Please ask for: Ms Iqraa Malik  
Email: [iqraa.malik@terraquest.co.uk](mailto:iqraa.malik@terraquest.co.uk)  
Telephone: 01212341390  
Our Ref: Y/121/20/HH  
Your Ref:  
Date: 30th October 2020

**Application for Planning Permission for Works or Extension to a Dwelling**

**Development:** Drop kerb  
**Location:** 14 East Bank North End Road Yapton BN18 0DJ

Proposed Plan - 1:100 @A1

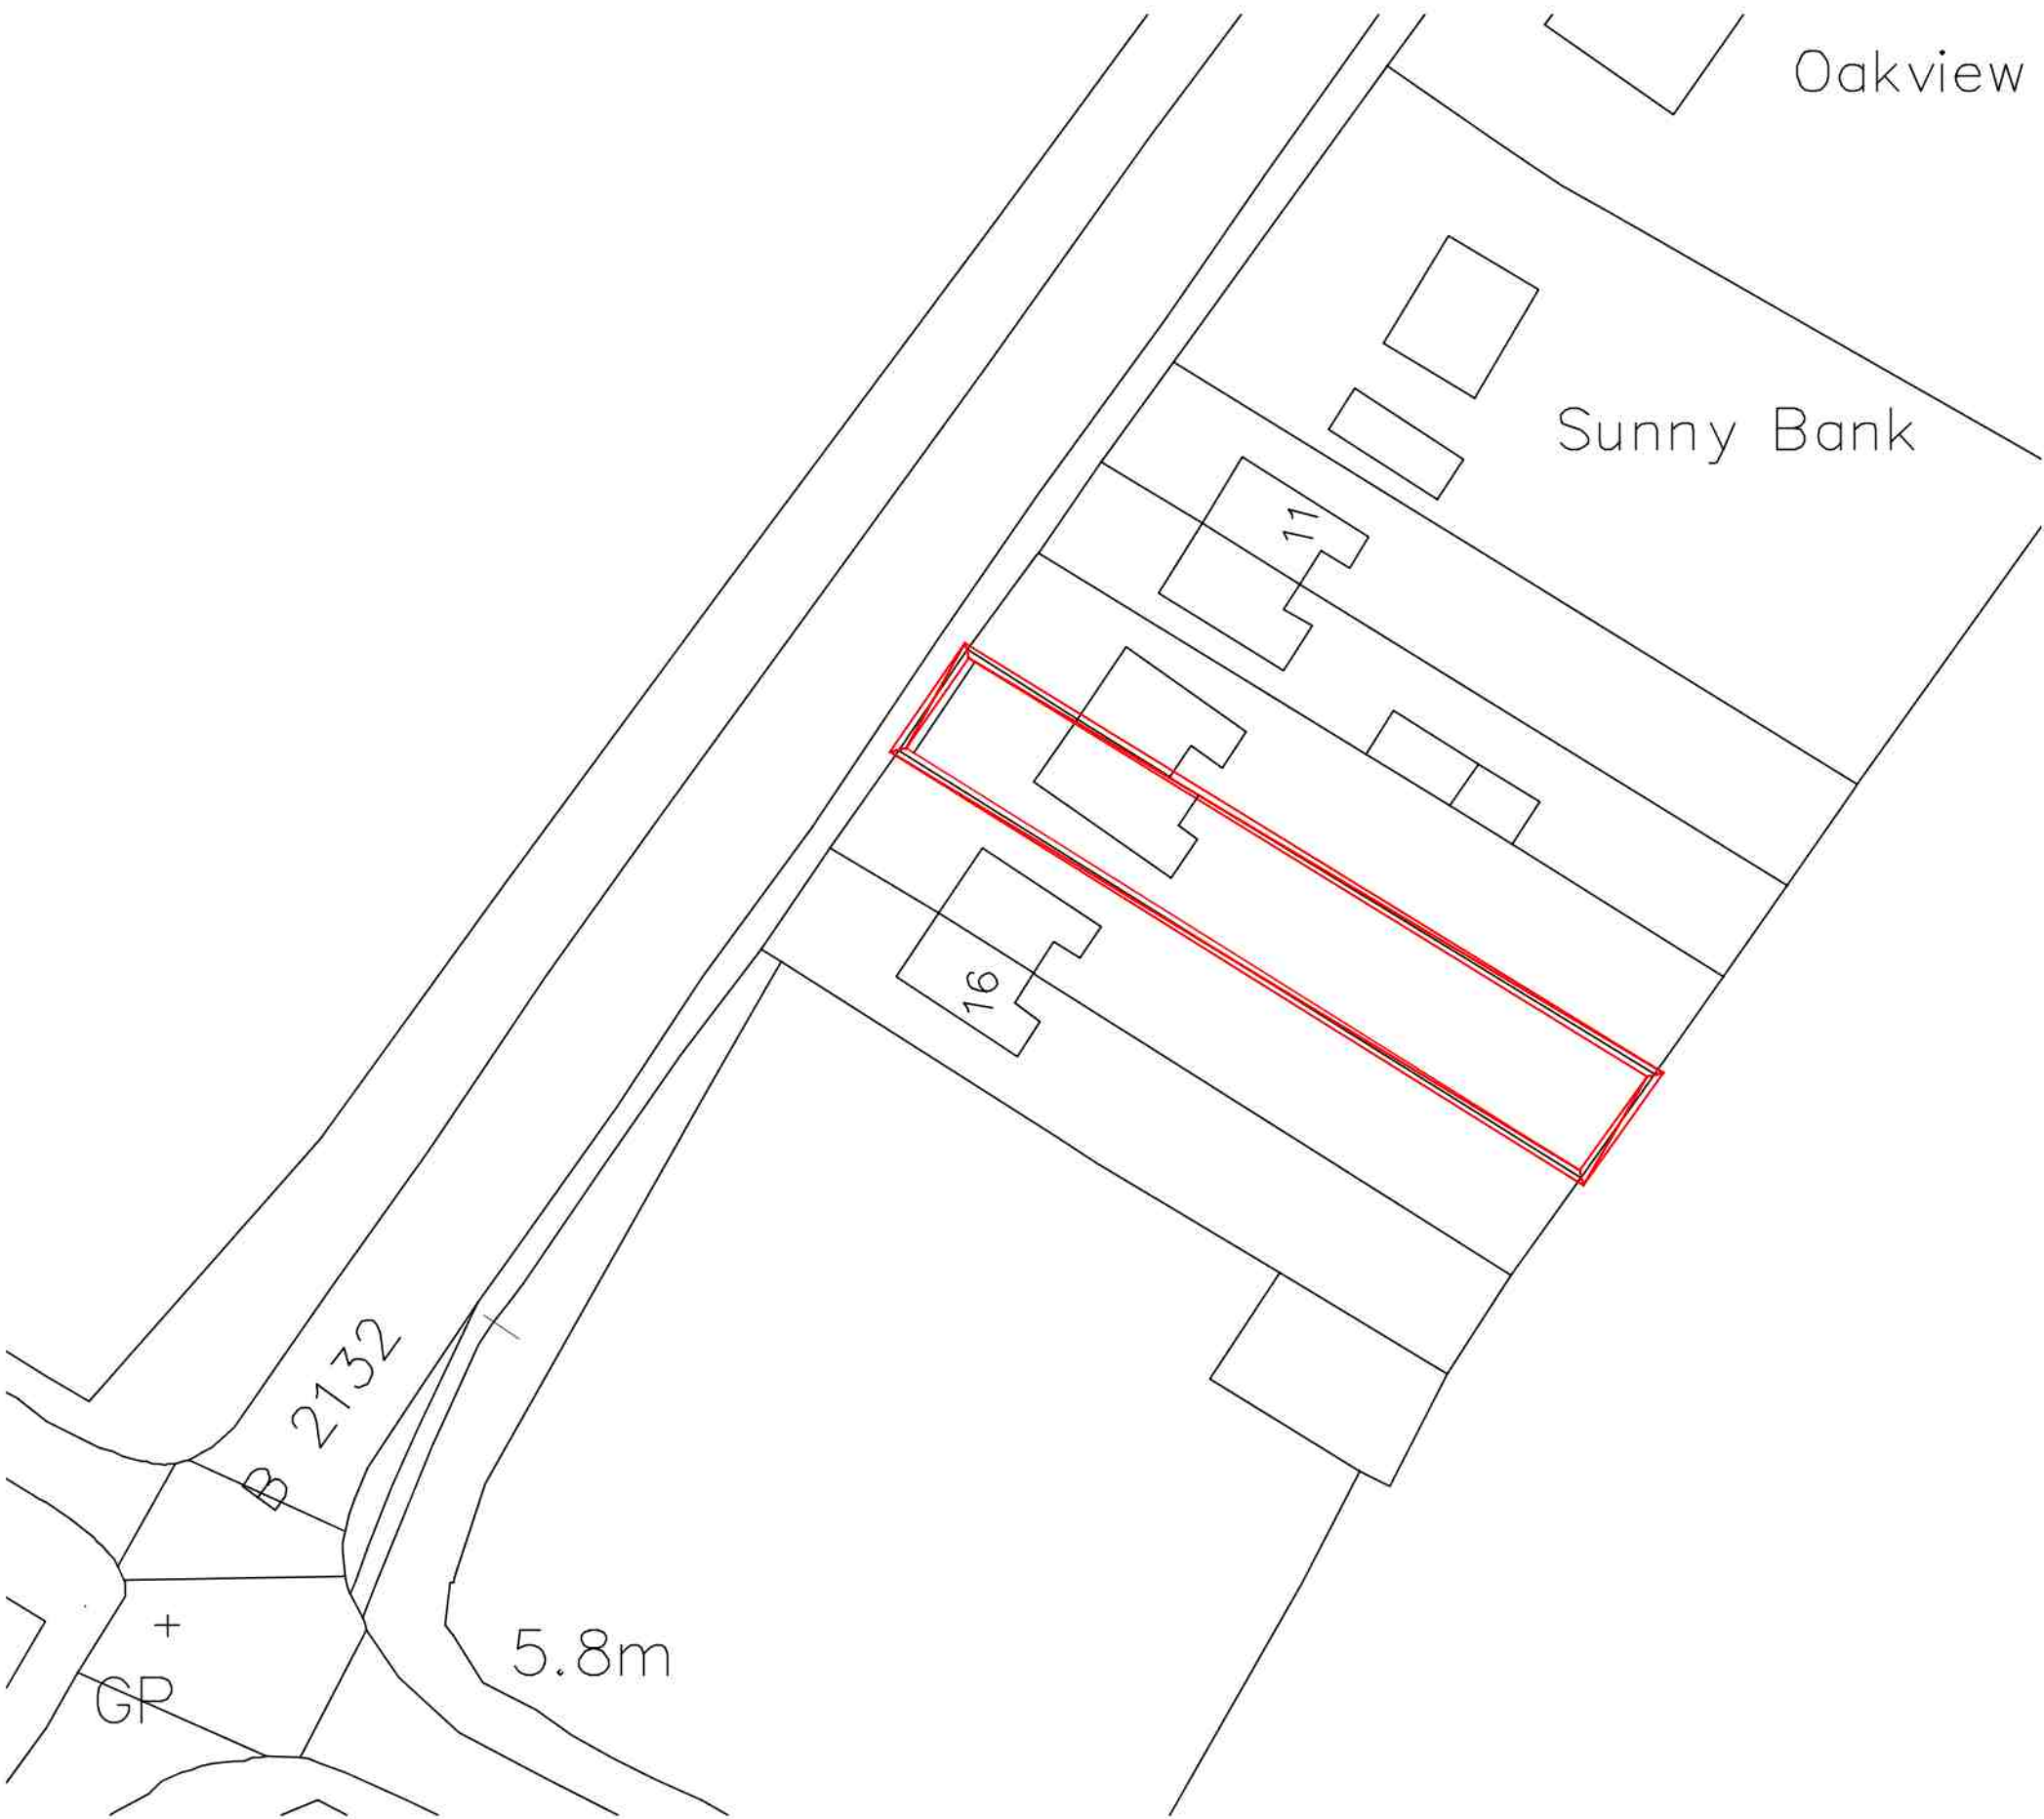
The proposed plan you have submitted does not measure to scale. Please amend.

Visibility Splays - 1:500 @A1

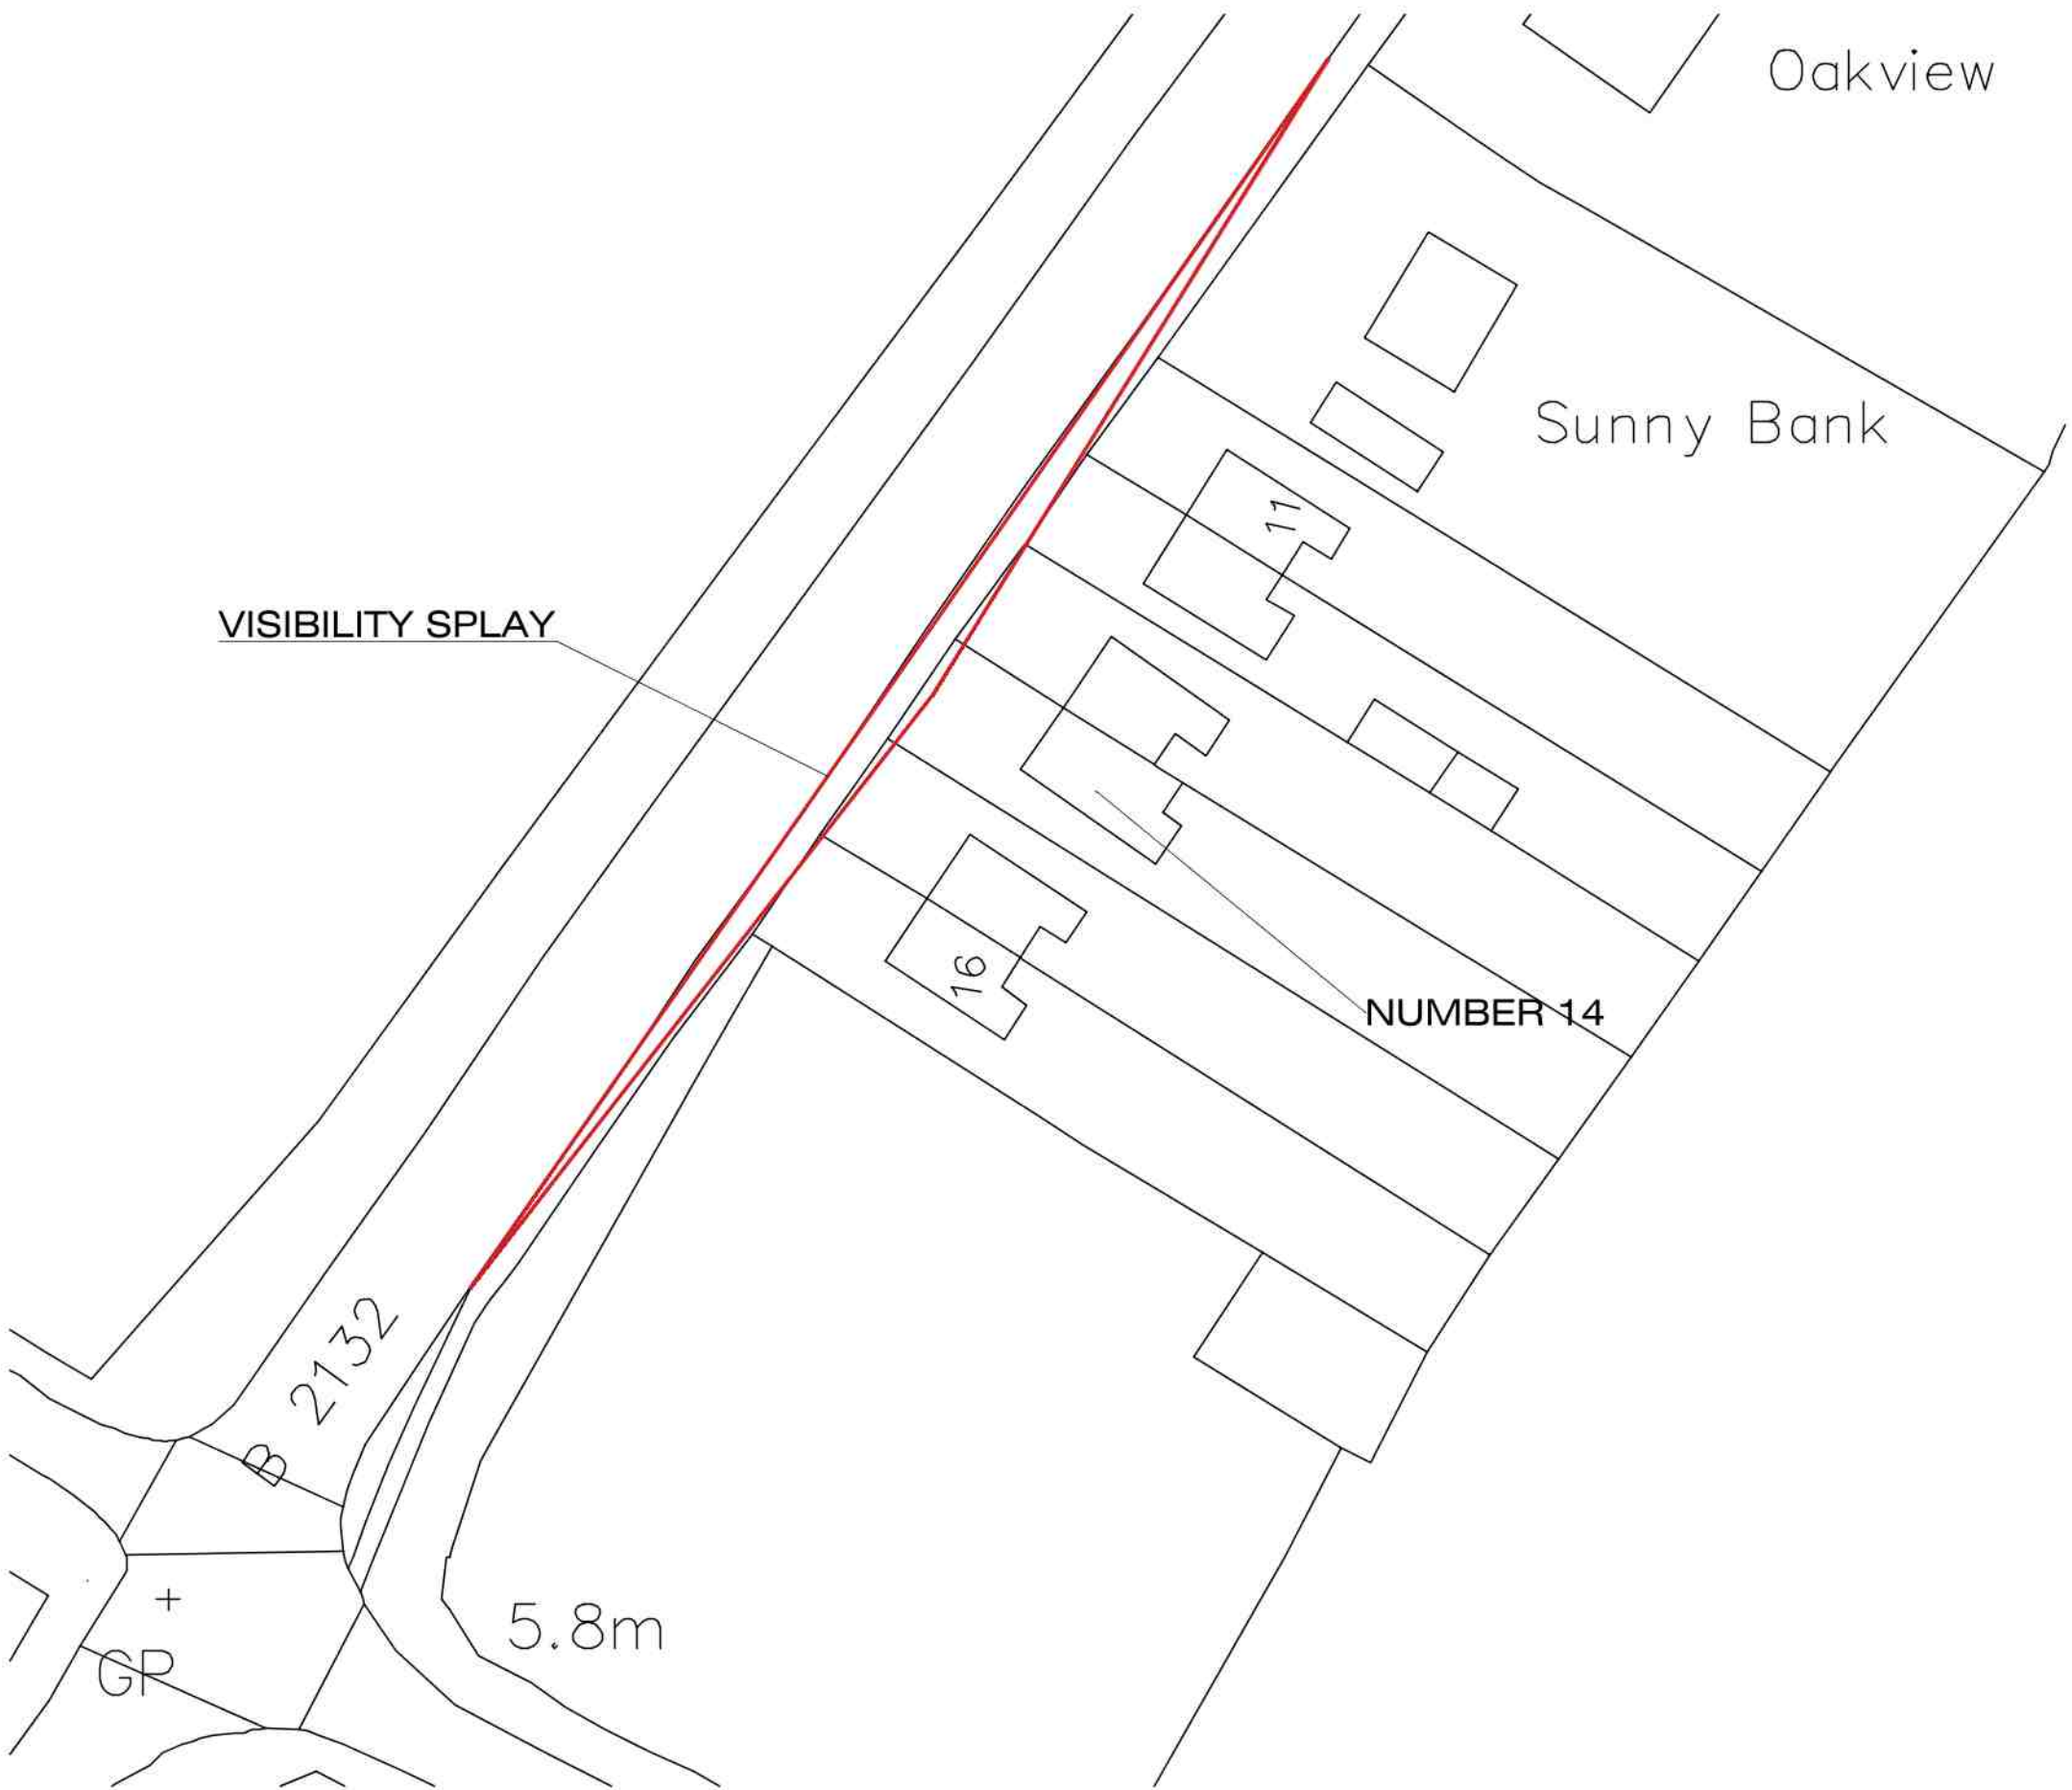
West Sussex County Council require that a visibility splay is provided. A splay is formed for a 30 mph speed limit road by measuring from a point 2.4m back from the kerb edge in the centre of the proposed access. A line should then be drawn from either side of this point for 43 m in each direction to the nearside edge of the carriage way. The splays must intersect and only within the control of the applicant, or within the publicly maintained highway.
